28 February 2024
L 240228 NS OPA Further Submission Covering Letter FINAL

**Outline Planning Application – Submission of Further Information
Mixed-Use Development of Land East of Oxford Road, Oxford (Site PR6a) (Water Eaton)
On behalf of Bellway Homes Limited and Christ Church, Oxford
Cherwell District Council Reference: 23/01233/OUT**

PROPOSED PR6A ACCESS STRATEGY AND CYCLE SUPER HIGHWAY - INCLUDING LEFT IN LEFT OUT PRIORITY AND PARTIAL CYCLOPS SIGNAL JUNCTION (SOUTHERN EXTENT)

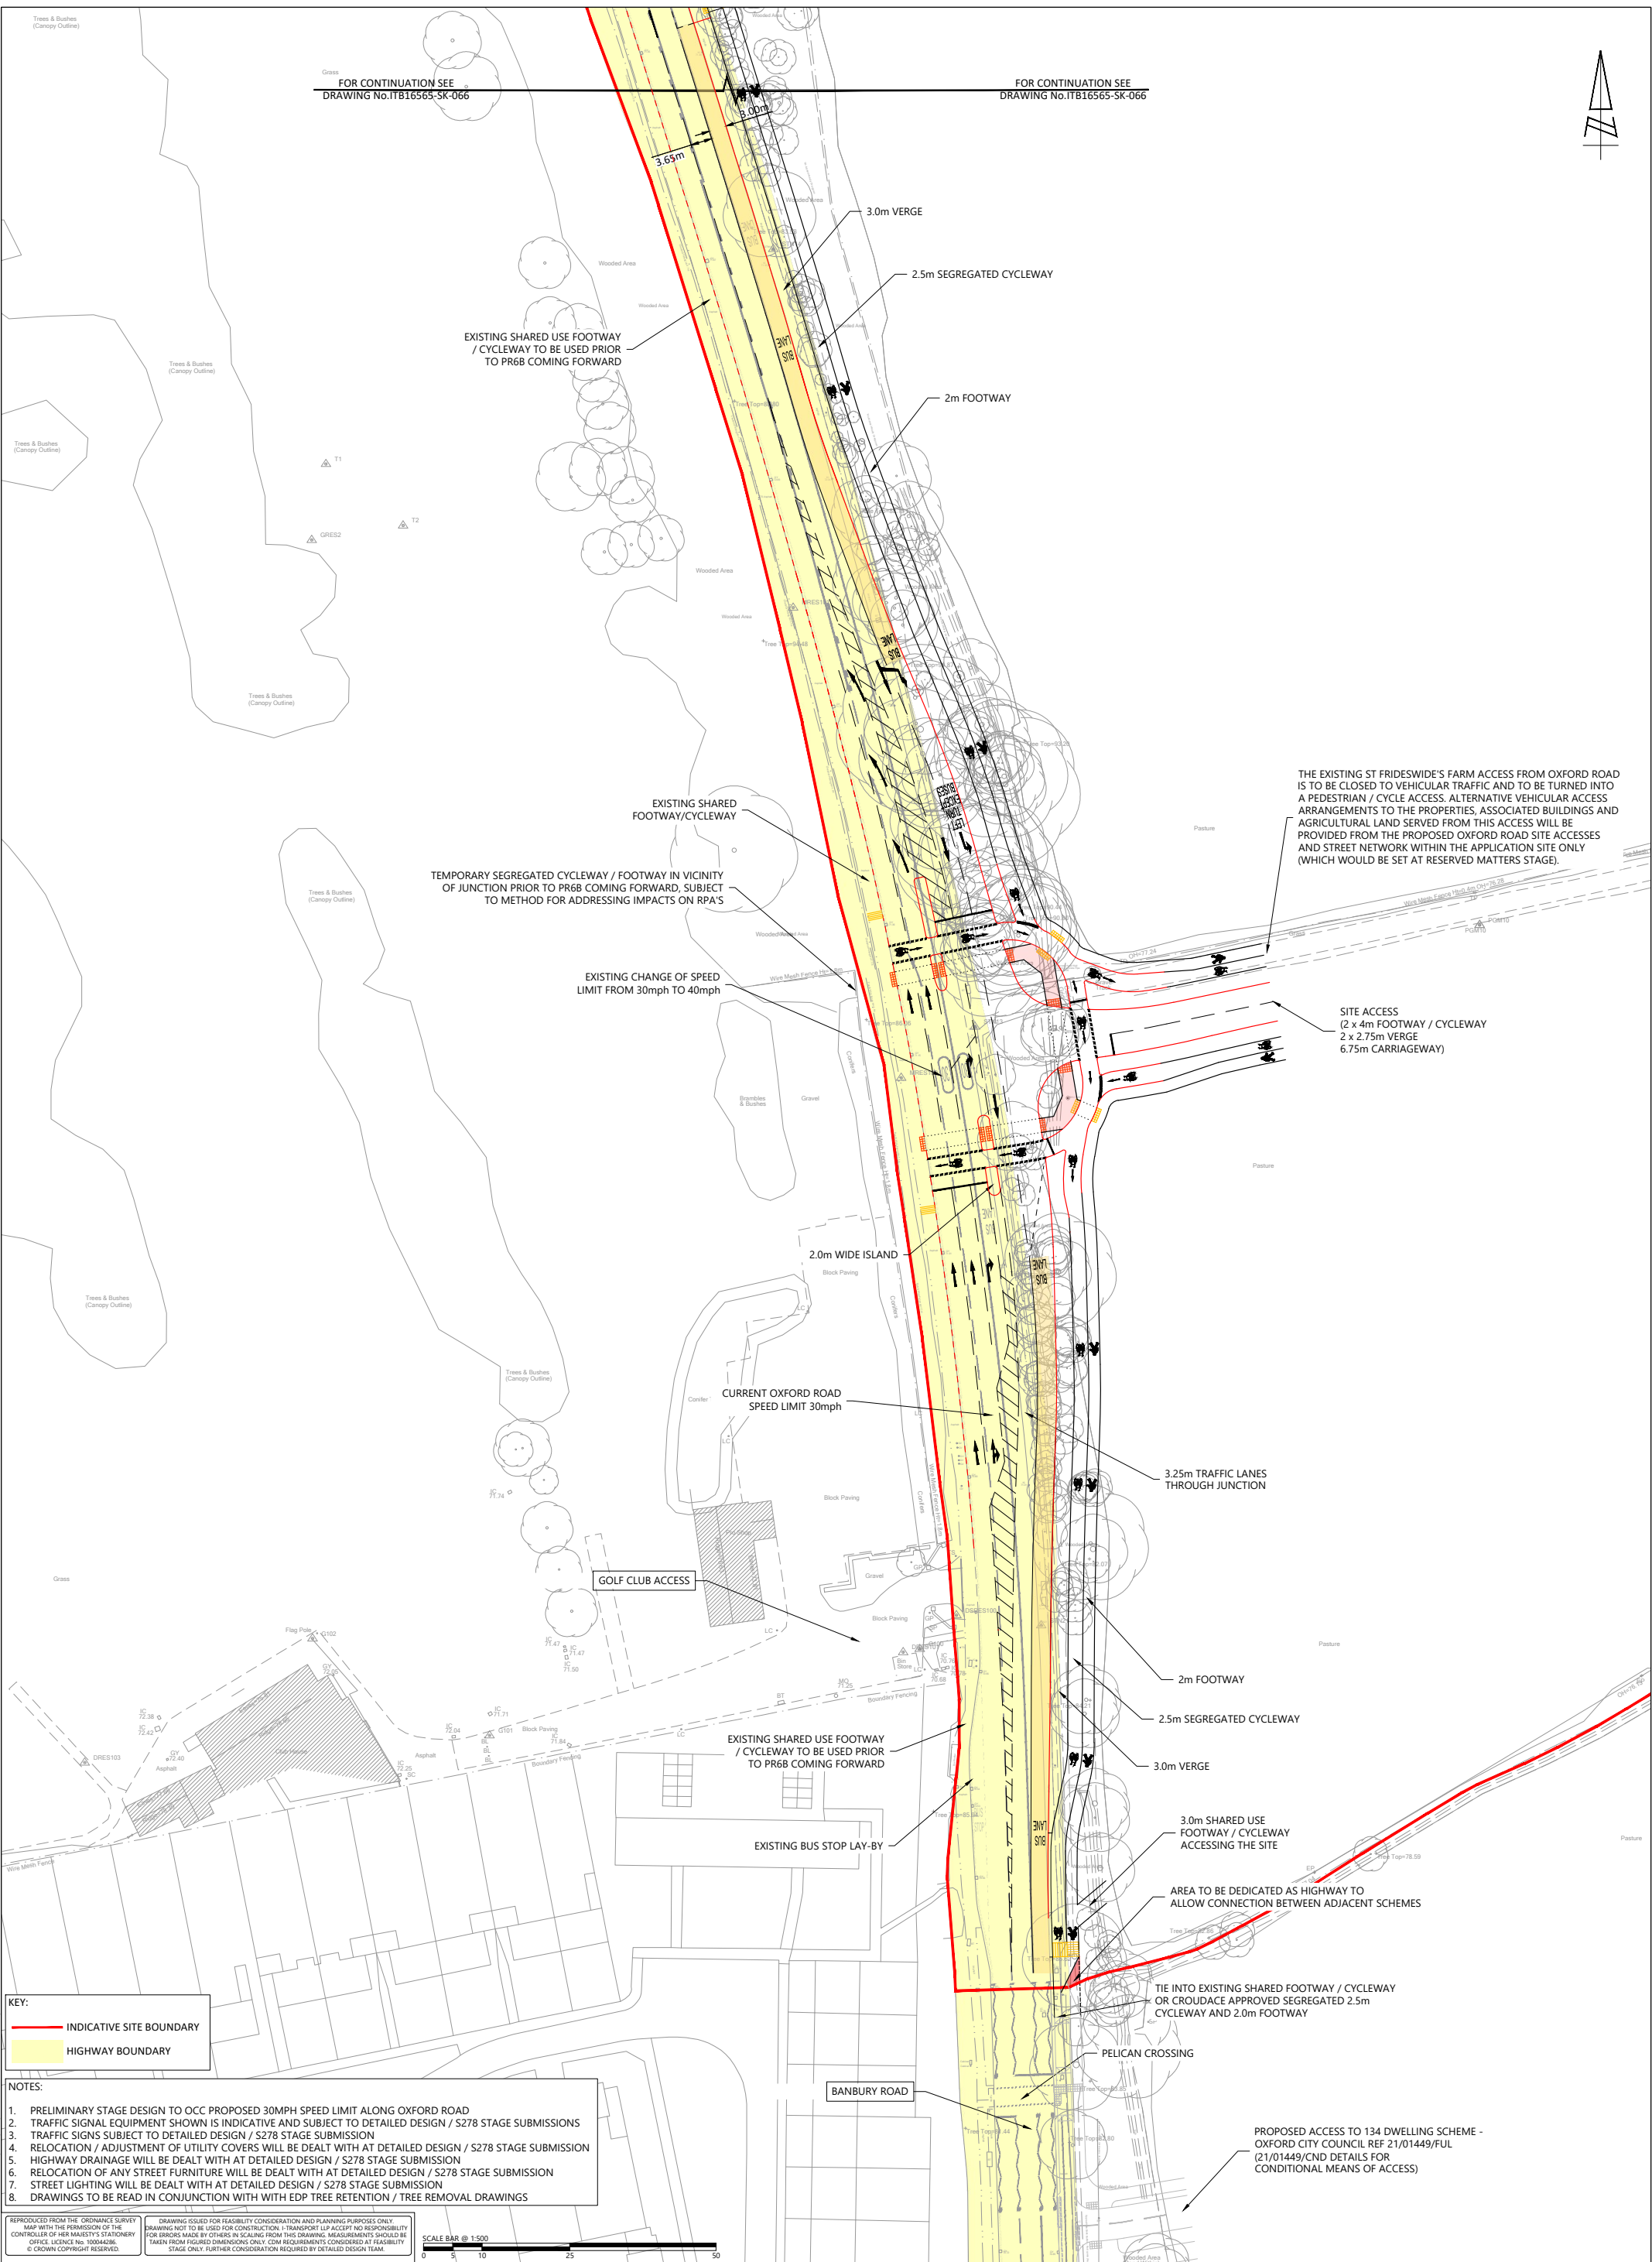
- (n) Minor amendments to the Oxford Road CYCLOPS access junction including safeguarding sufficient space for a right turn movement into PR6b on the northern arm.
- (o) Confirmation that a pedestrian / cycle access from the site is provided to the Parkway / Station / Park and Ride site to the north. It is envisaged that the Section 106 Agreement will secure a pedestrian / cycle link as far as the site boundary in this location.
- (p) An assessment demonstrating why it is not appropriate for the site to be car-free and that parking details are better addressed at Reserved Matters stage.
- (q) Identification of an improvement scheme at Cutteslowe roundabout.
